Consultee Comments for Planning Application 23/00950/FUL

Application Number: 23/00950/FUL

Address: Units 1 And 2 Tan Yard Road Catterall Preston Lancashire PR3 1YH

Proposal: Proposed change of use of the existing building to 1No dwelling (C3), with external alterations including addition of pitched roof, following demolition of part of the building

Project Title	Proposed detached dwelling
Client	Mrs Cerani
Drawing Title	Existing/proposed site plan

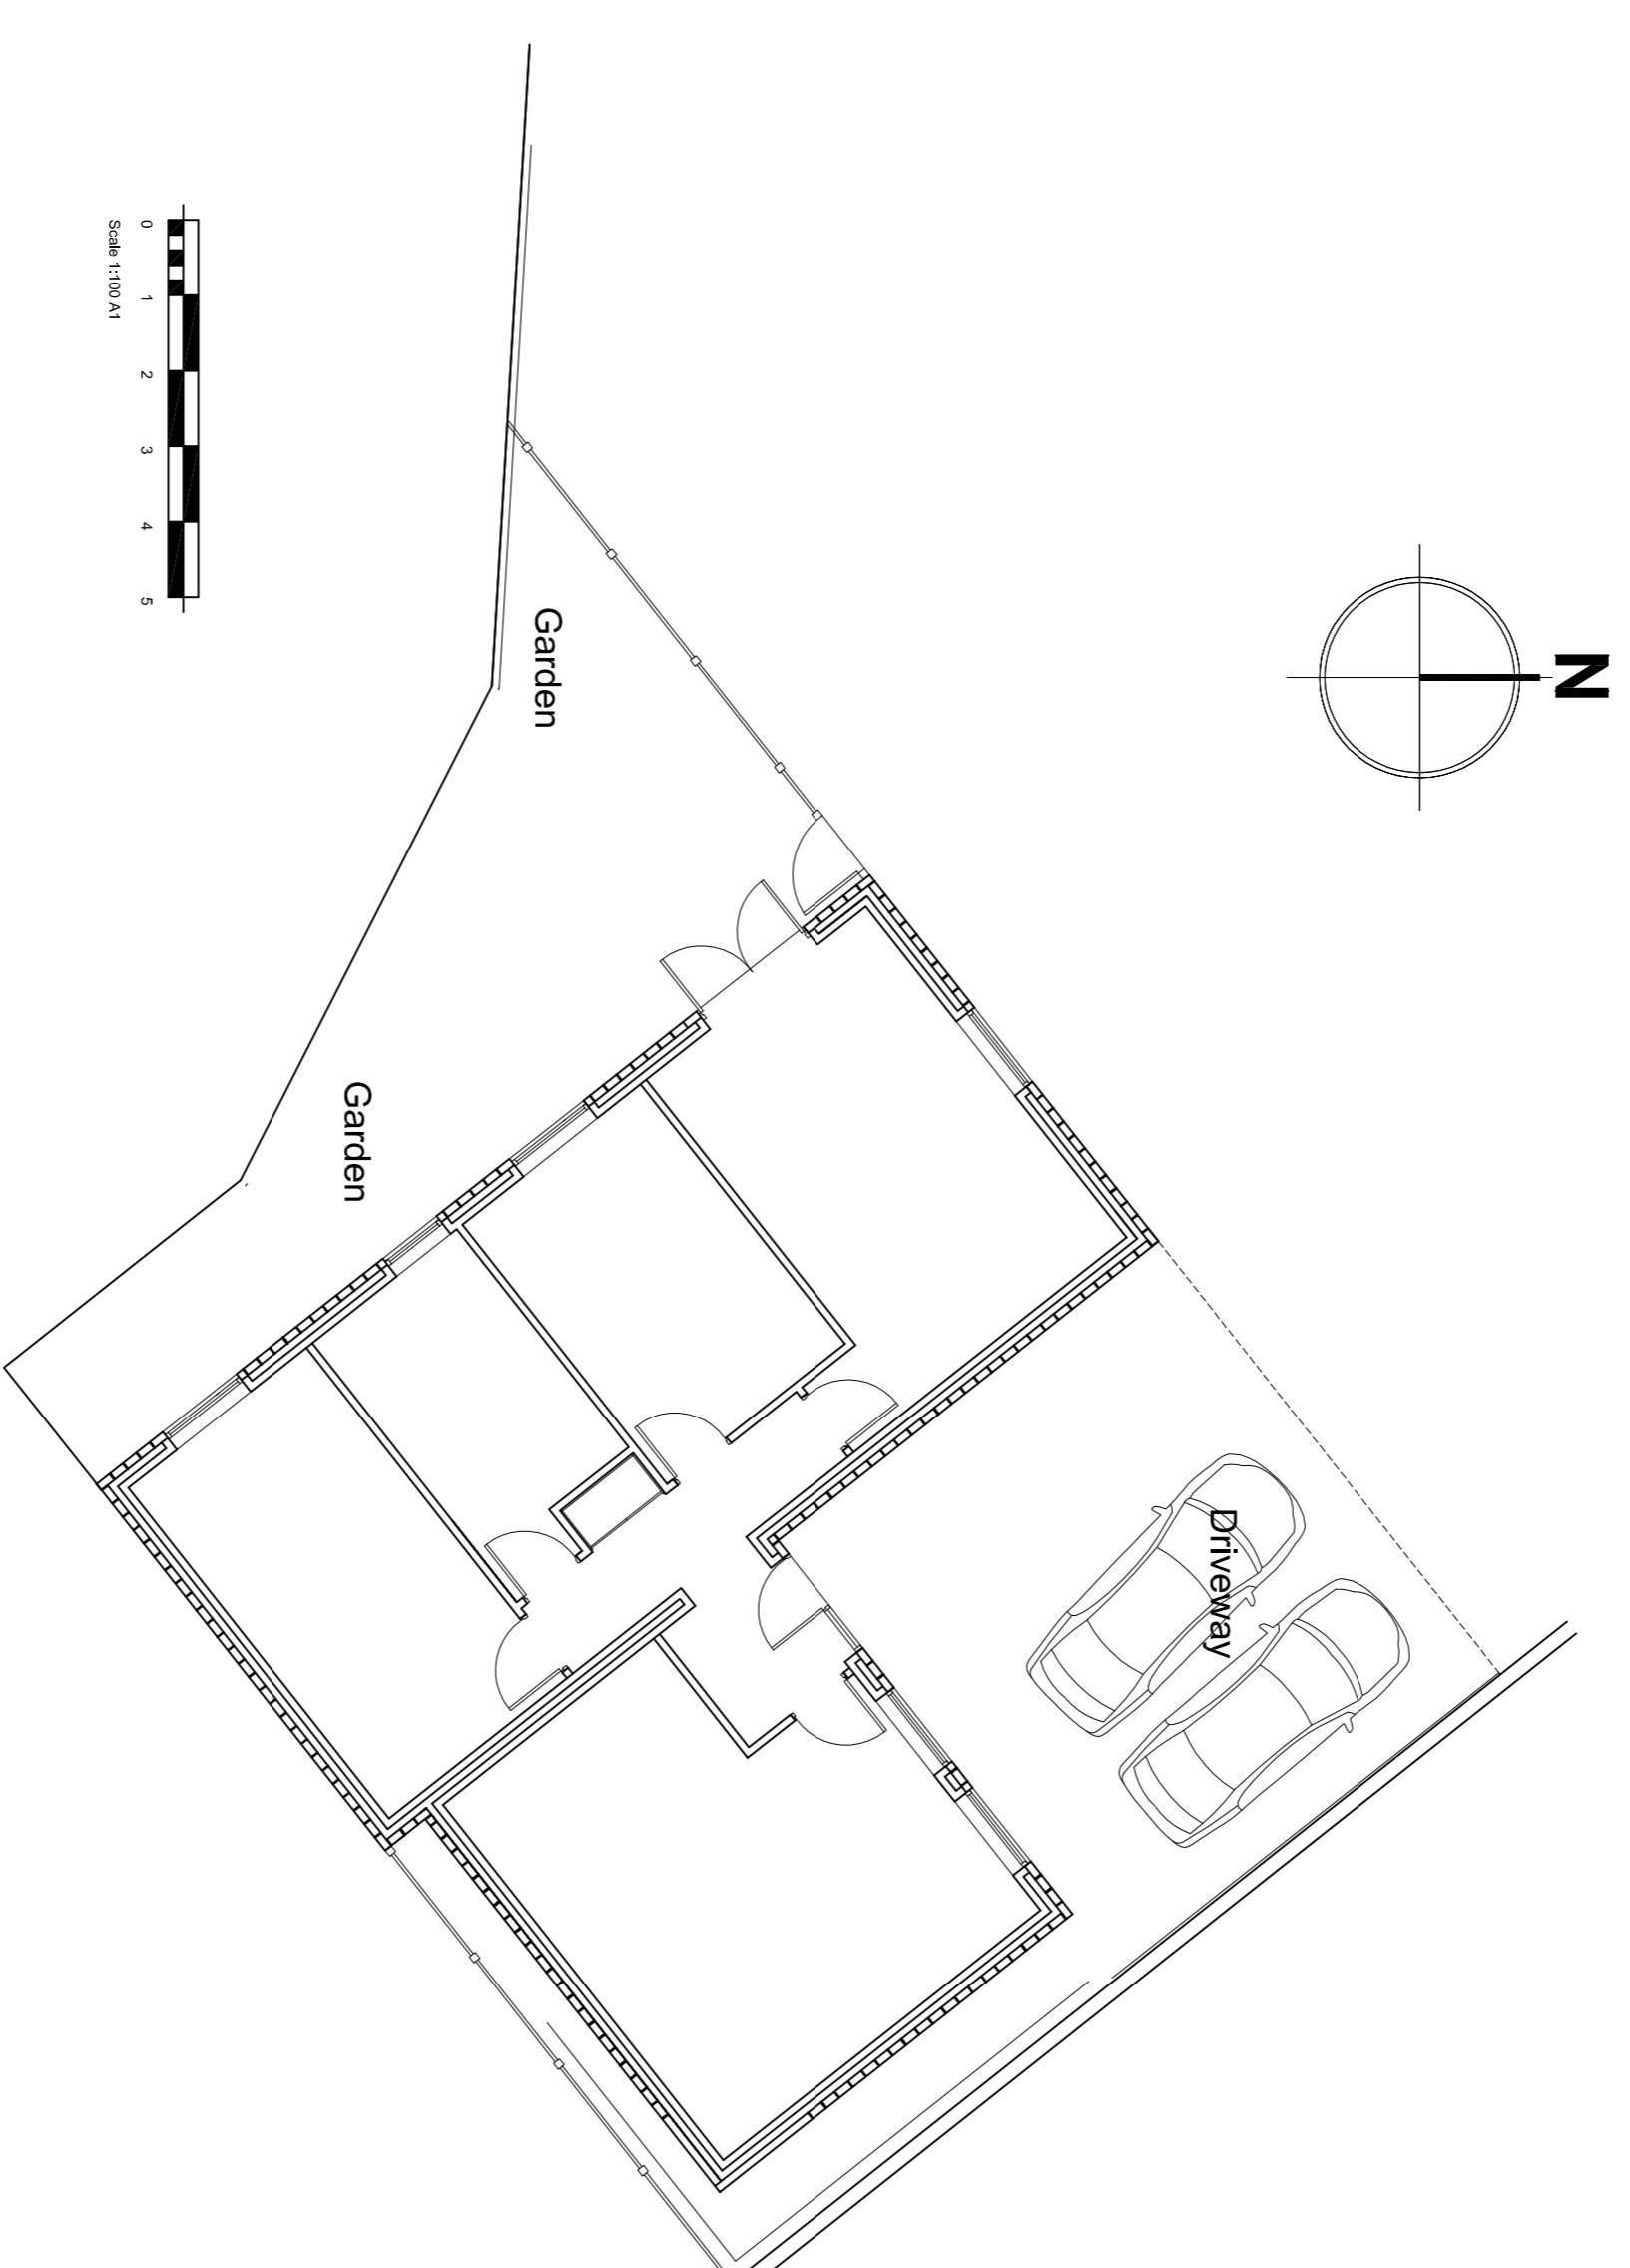
From recollection there is a hedgerow running alongside the western / south western boundary. How much of the hedgerow extends into the site I am not aware. Pleas could it be clarified if the intention is to remove the hedgerow and replace with close board fencing or cut back the hedgerow and install the fencing?
